From: Thomas Callaway
Sent: 13 April 2017 13:30
To: Planning.Responses
Subject: RE: Planning Consultation on: LU/94/17/OUT

Engineers comments in respect to surface water drainage:

Registered: 20th March
2017
Site Address: Westholme Nursery Toddington Lane Littlehampton BN17 7PP
Grid Reference: 503415 103978
Description of Works: Outline application with all matters reserved for residential re-development comprising of 10 No. dwellings & associated works (resubmission following LU/327/16/OUT).

Drawing Title
Drainage Layout

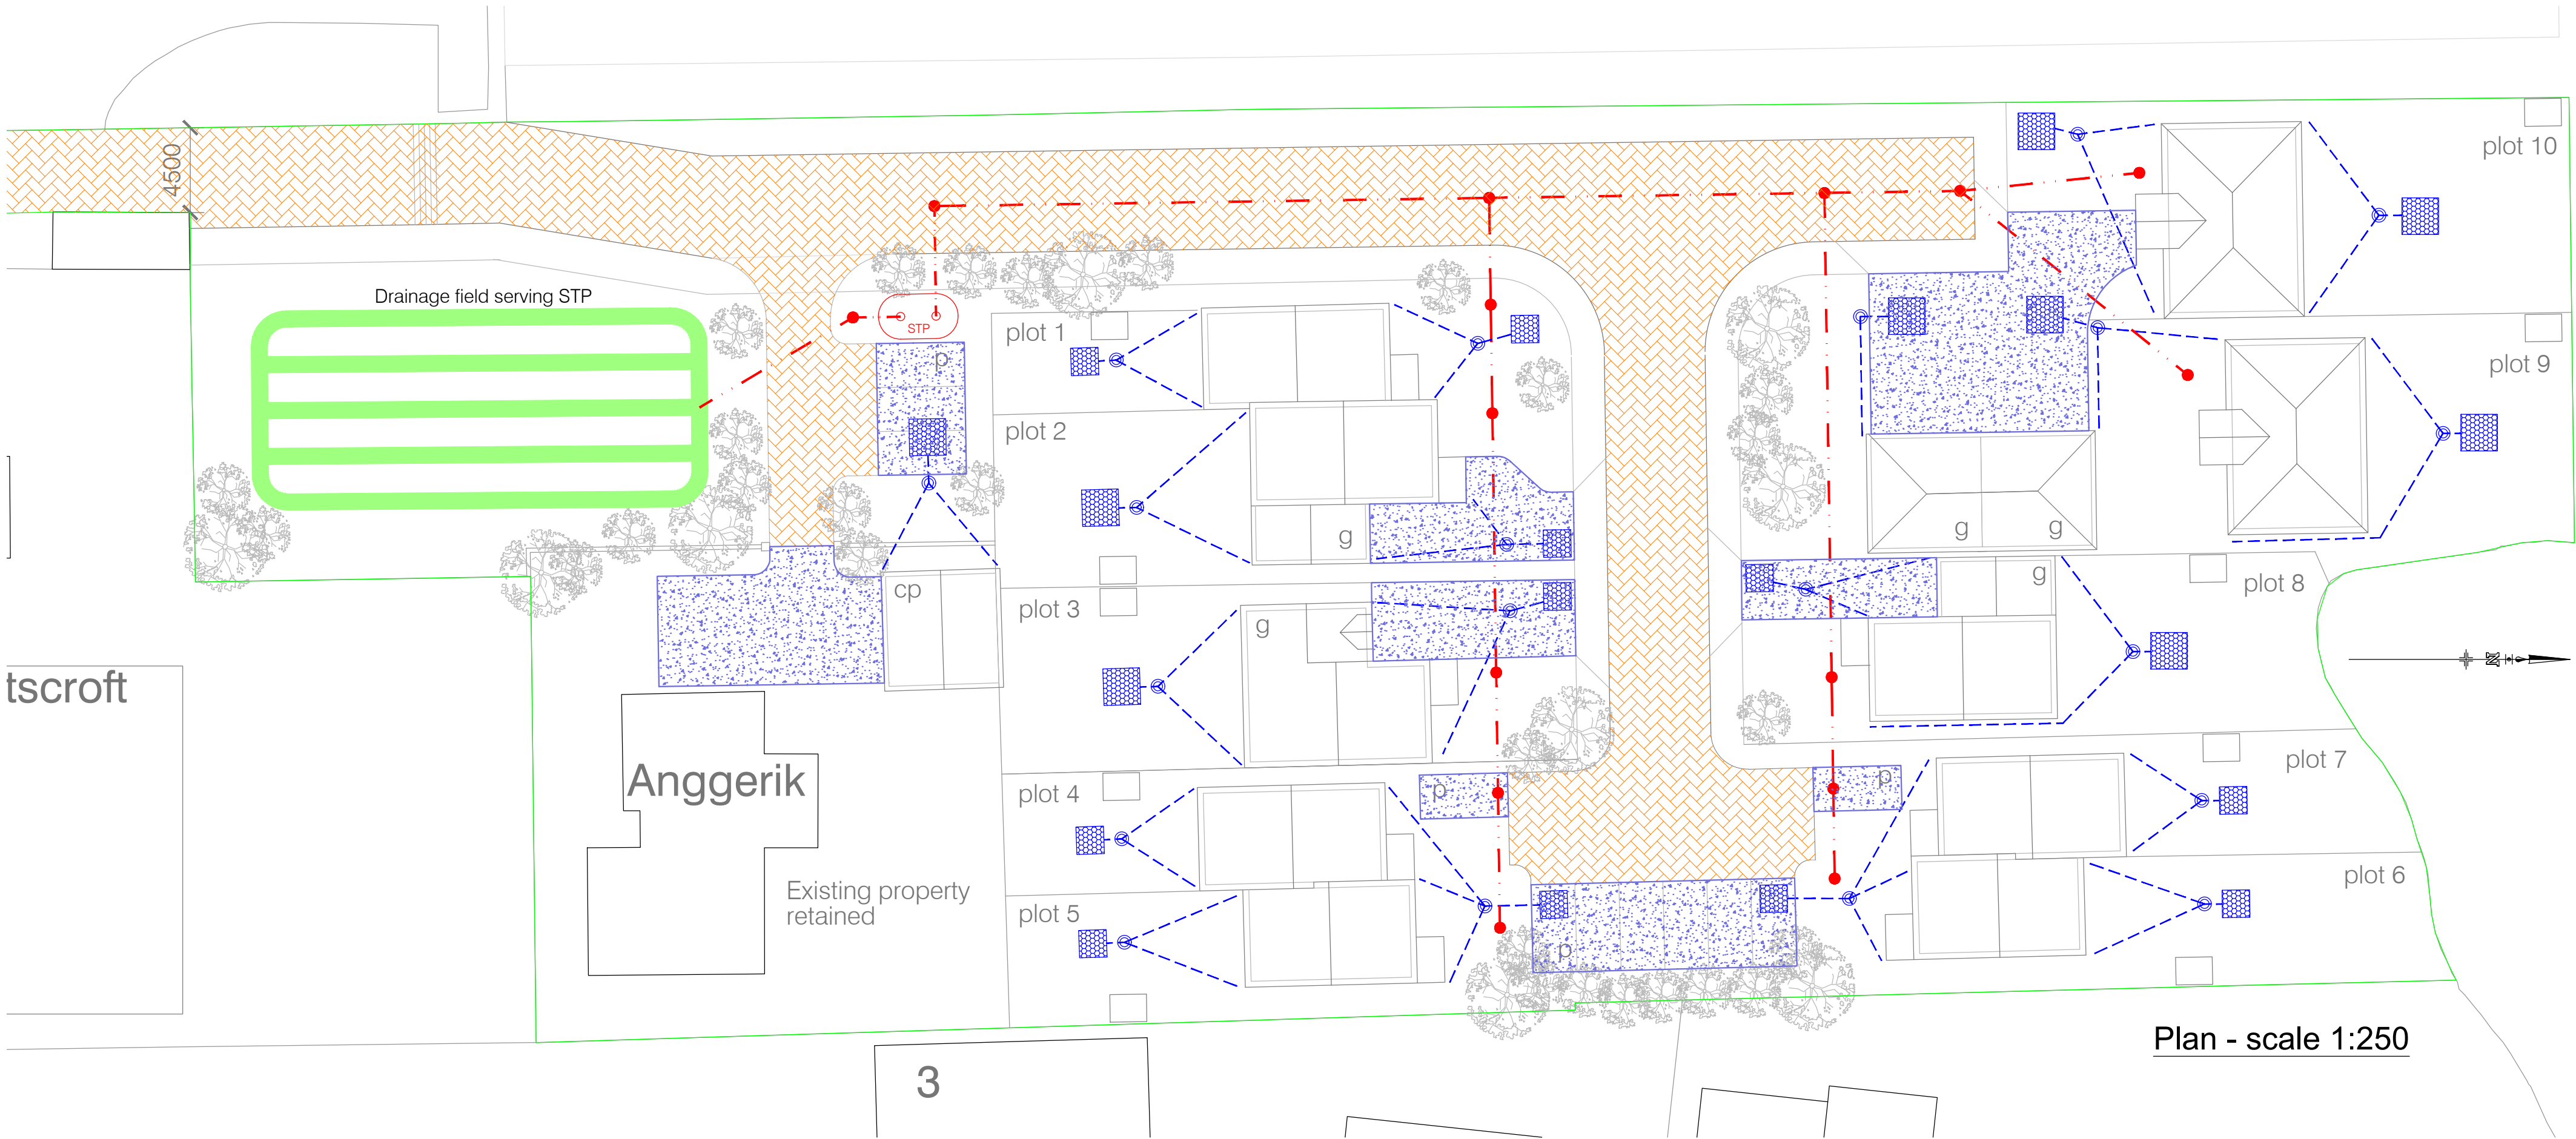
Soakaways and permeable paving are proposed. Initial percolation tests and groundwater monitoring suggest infiltration will be fine. Further testing and monitoring required for detailed design. Foul drainage will require permit from the EA.

Infiltration rates for soakage structures are to be based on percolation tests undertaken in the winter period at the location and depth of the proposed structures. The percolation tests must be carried out in accordance with BS 365, CIRIA R156 or a similar approved method and cater for the 1 in 10 year storm between the invert of the pipe to the soakaway, and the base of the structure. It must also have provision to ensure that there is capacity for the system to contain below ground level the 1 in 100 year event plus 30% on stored volumes, as an allowance for climate change. Adequate freeboard must be provided between the base of the soakaway structure and the highest recorded annual groundwater level identified in that location.

Any SuDS or soakaway design must include adequate groundwater monitoring data to determine the highest groundwater table in support of the design. The applicant is advised to discuss the extent of groundwater monitoring with the Council's Engineers. Supplementary guidance notes are also enclosed for information.
